**Application by Morgan Offshore Wind Limited, Morecambe Offshore Wind Limited ("the Applicant") for an Order granting Development Consent for the proposed Morgan and Morecambe Offshore Wind Farm Transmission Assets ("Project")**

The following constitutes Natural England's formal statutory response to the Secretary of State's Request for Information (RFI) dated 20 May 2026. To inform this response Natural England have reviewed the following documents:

Figure 1-7: An indicative layout of the proposed measures at Crossens Outer and Banks Marsh

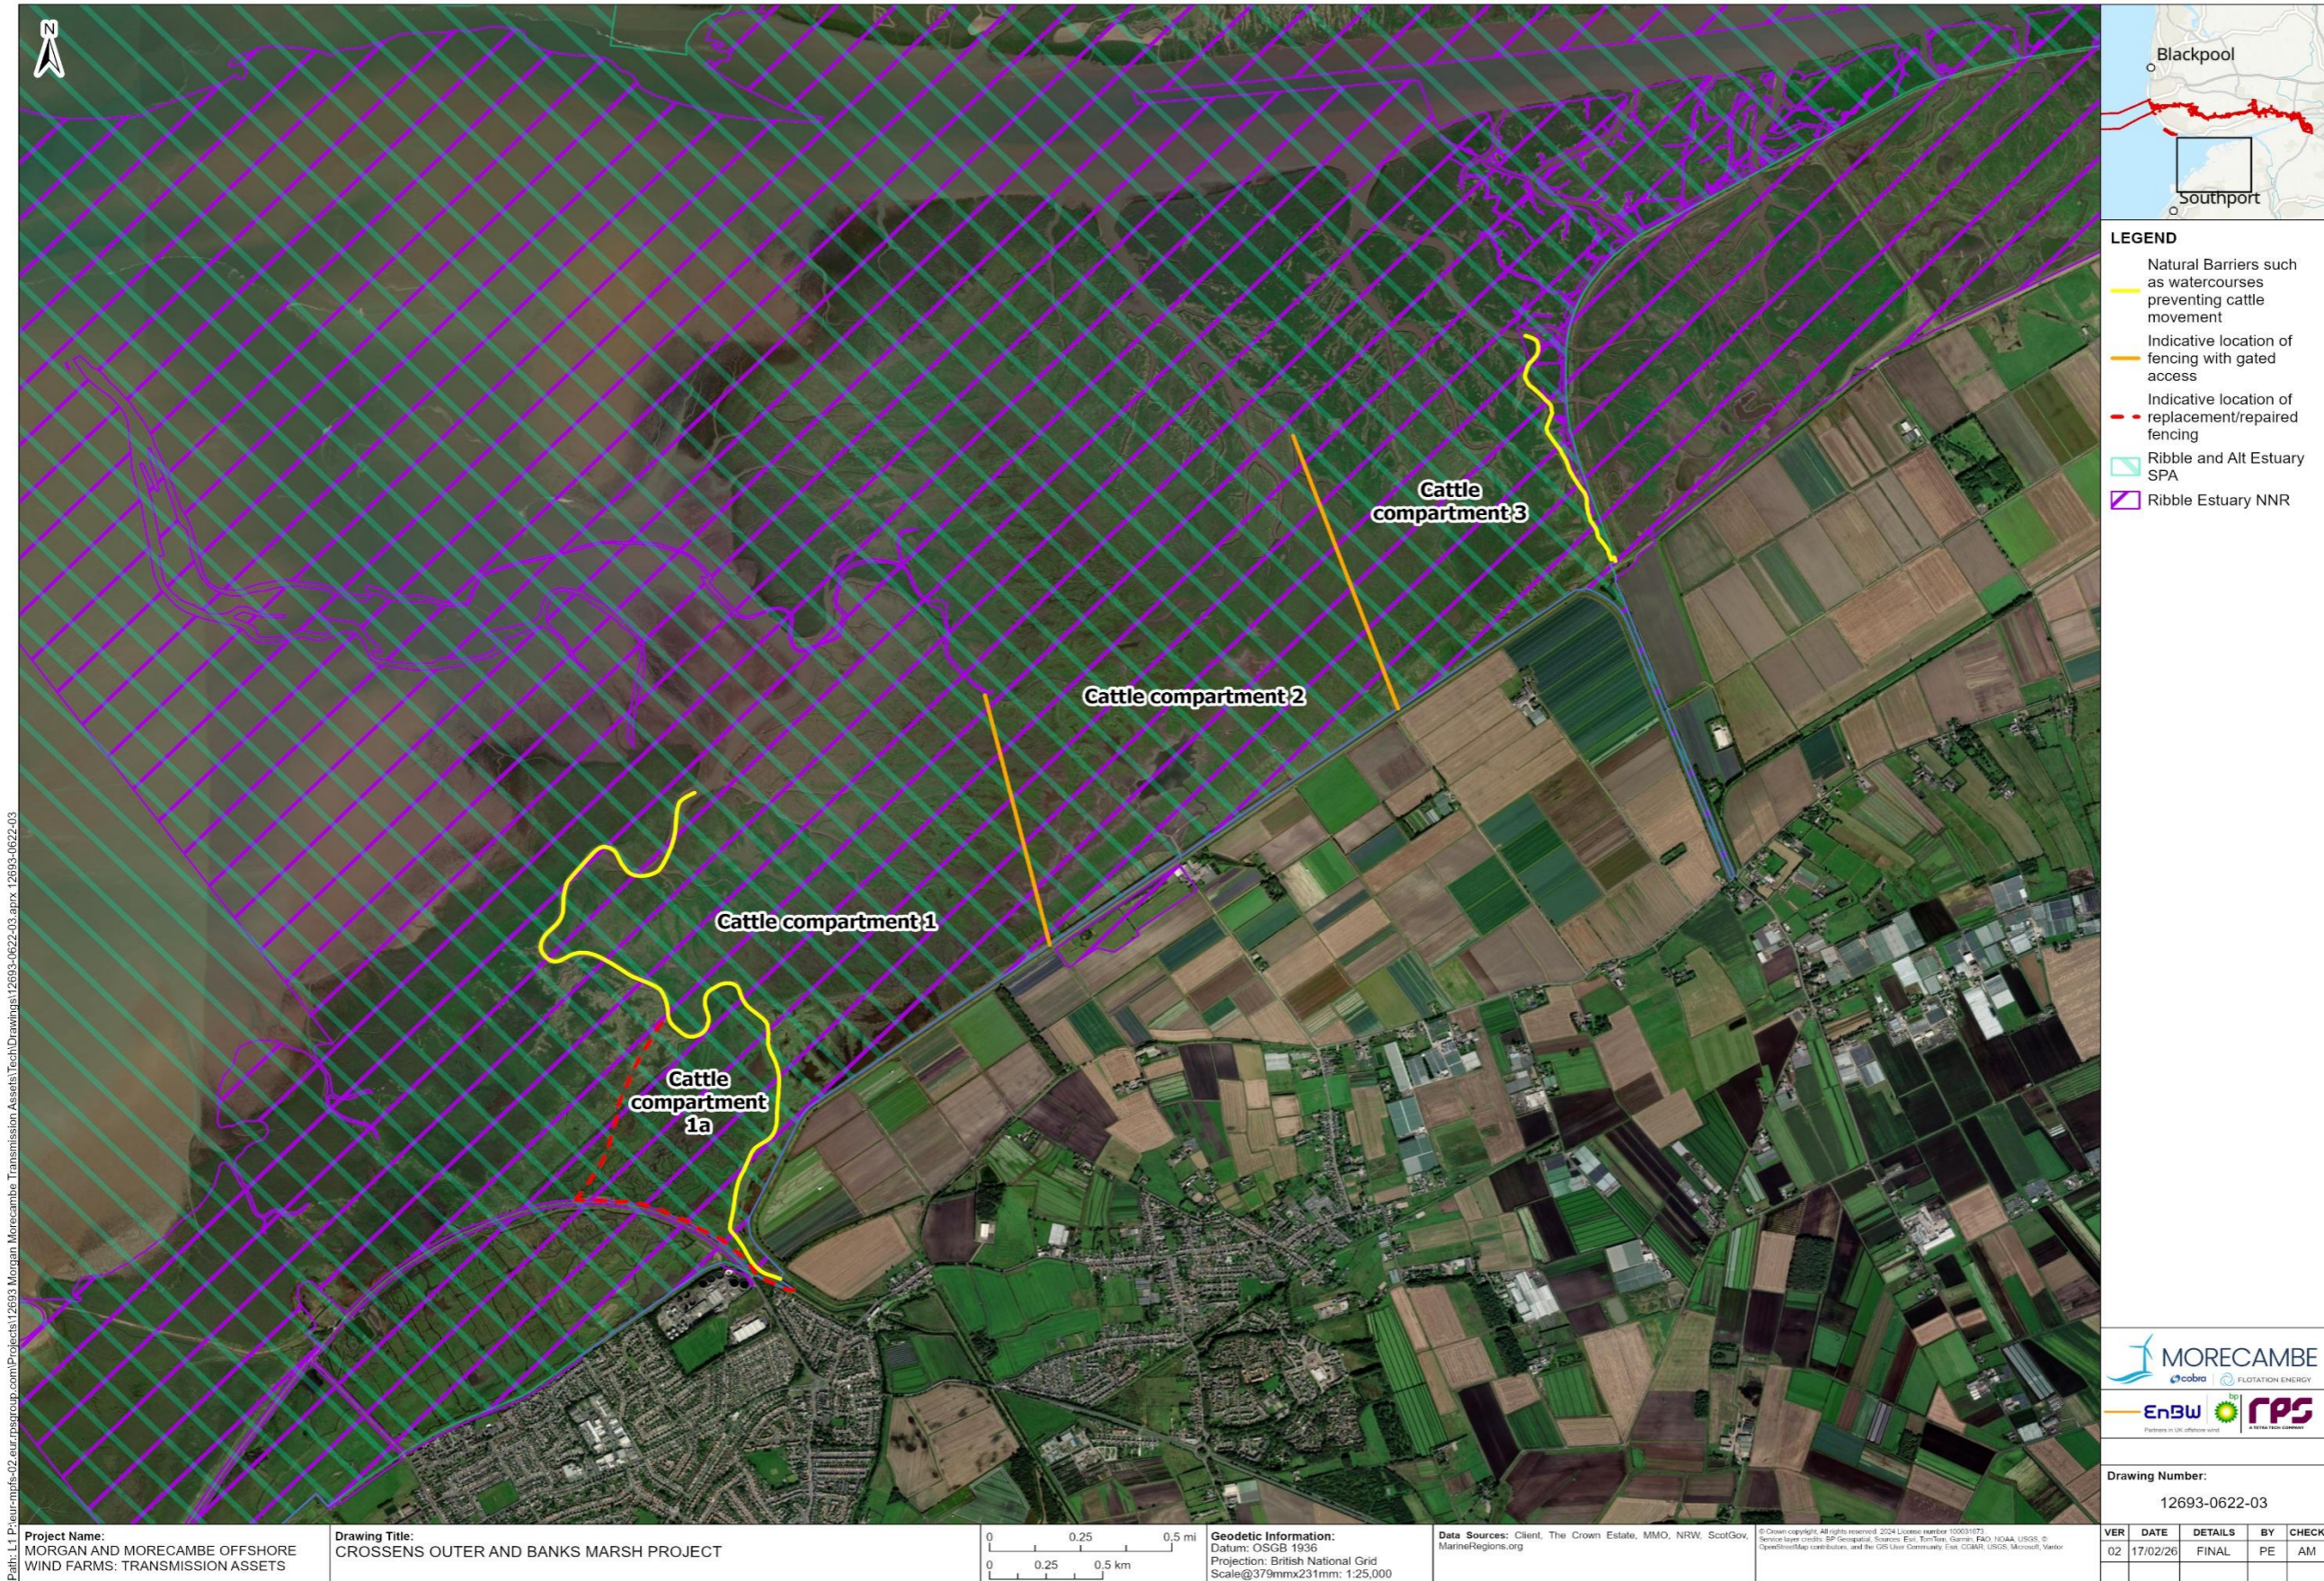
As set out in response to Question 15, Natural England has not been provided with sufficient evidence to demonstrate that the proposed measures are additional to existing or baseline site management. The measures described, including grazing management and access control, appear broadly consistent with existing management approaches at the Ribble Estuary NNR. As such, it is currently unclear whether these proposals would deliver ecological benefits over and above those already expected through ongoing site management.

Natural England considers that, while the proposed measures may deliver localised habitat improvement, they are relatively modest in scale and nature. The proposals primarily relate to refinement of grazing management and reduction of disturbance, rather than the creation or restoration of habitat providing clearly defined compensatory function equivalent to that being lost. Further evidence would be required to demonstrate that these measures would reliably offset the identified impacts to golden plover and the other waterbird features identified.

Natural England does not currently have confidence in the proposed delivery mechanism. Although the OEMP (F07) suggests that the Applicant would take responsibility for implementation, the governance structure, delivery arrangements and allocation of responsibilities remain unclear.

There remains some uncertainty regarding the compatibility of the proposed measures with other constraints, including aviation safeguarding. Natural England has not seen evidence that the full proposals have been agreed with relevant aviation stakeholders. Given previous constraints in this location, confirmation from aviation stakeholders would be necessary to demonstrate that the measures are deliverable in practice.
